Pre-Application Enquiry Response

Pre-Application Number: 22/00515/PREAPP

Enquiry Site: 10 Kingsdown Road, Epsom, Surrey, KT17 3PU

Enquiry Proposal: New ground floor rear extension, first floor side infill extension, new rooflights to main roof.

02 - PROPOSED FRONT ELEVATION

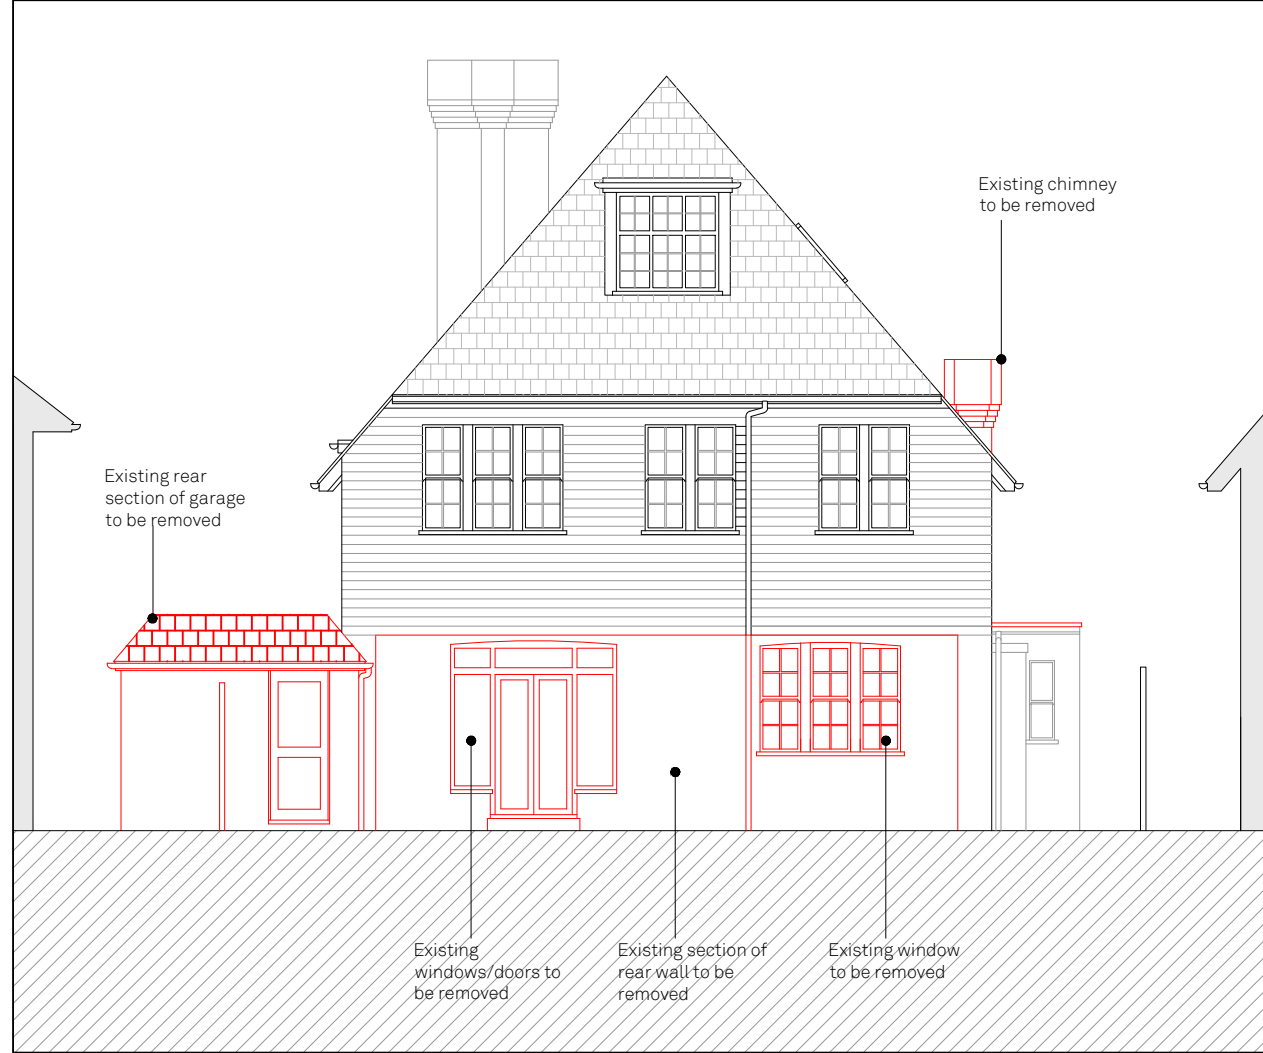
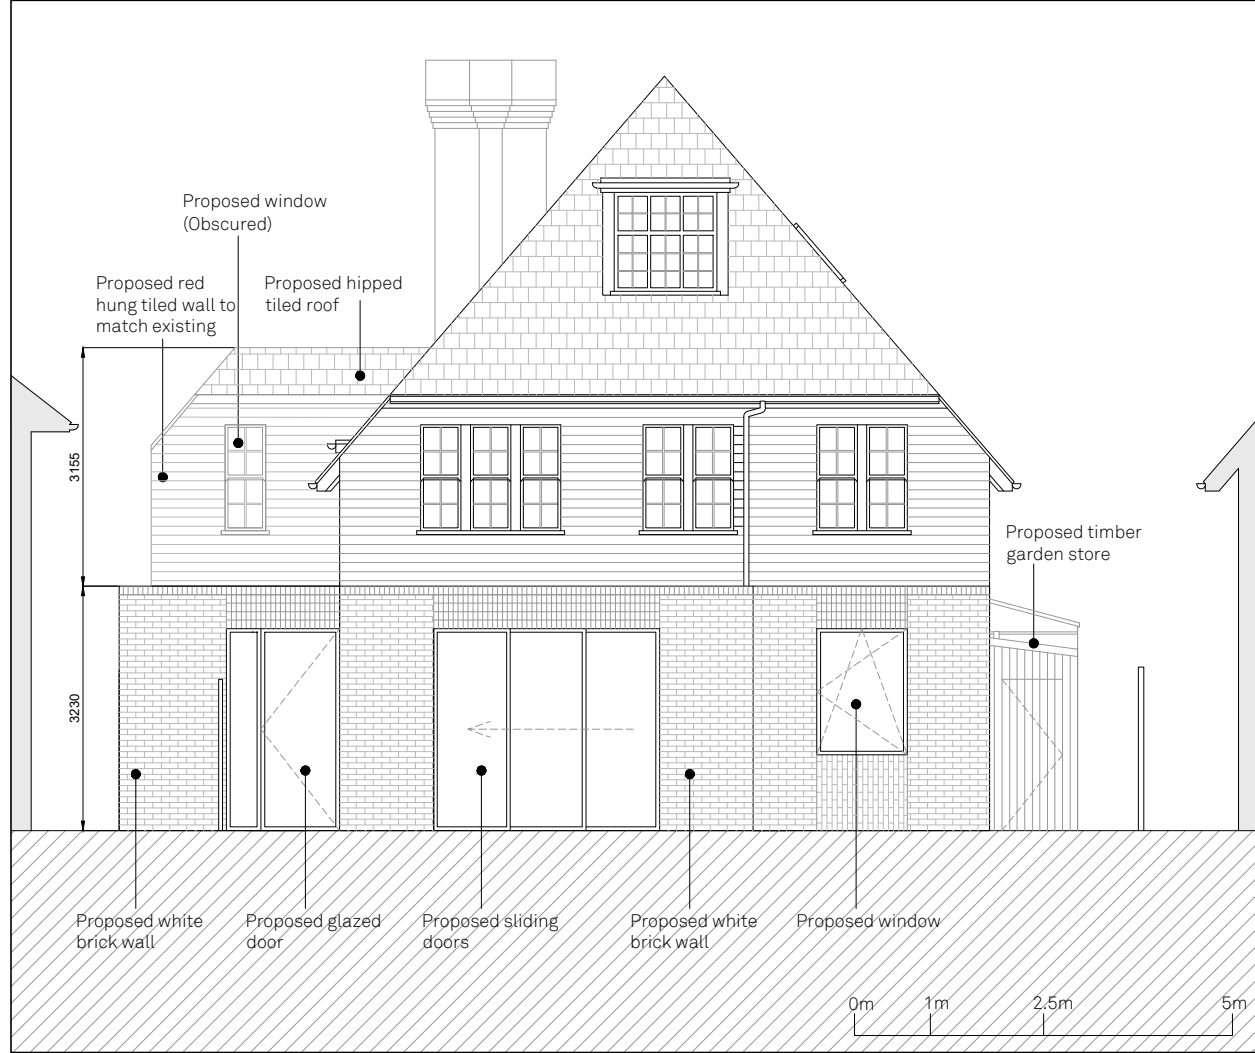
they are an improvement over the previous refused scheme, in particular in terms of fenestration details, the proposed first-floor side extension needs to be stepped in from the side boundary, ideally by 1m, and the roof would need to be redesigned to integrate with the one in the host dwelling.

12. The amended plan shows the flat roof being amended to a hipped roof that would integrate into the main roof, whilst appearing sufficiently subservient. The front and rear eaves would match the eaves of the main roof and the roof tiles would also match the existing roof tiles. The windows will be to the same design and proportions as the ones in the host dwelling, to both the front and the rear of the extension and hung tiles would be used to the external walls to match those on the first floor of the host dwelling.

13. I understand that setting in the extension by 1m from the side boundary would make this element of the proposal unviable, so we compromised in setting it to align to the existing hipped roof of the garage, increasing the gap to the neighbouring property to 1.6m.

14. I am of the view that the Council's concerns with regards to the design of the first-floor side extension have been sufficiently addressed and there are no issues with the single storey rear extension element of the enquiry proposal and the proposed roof lights.
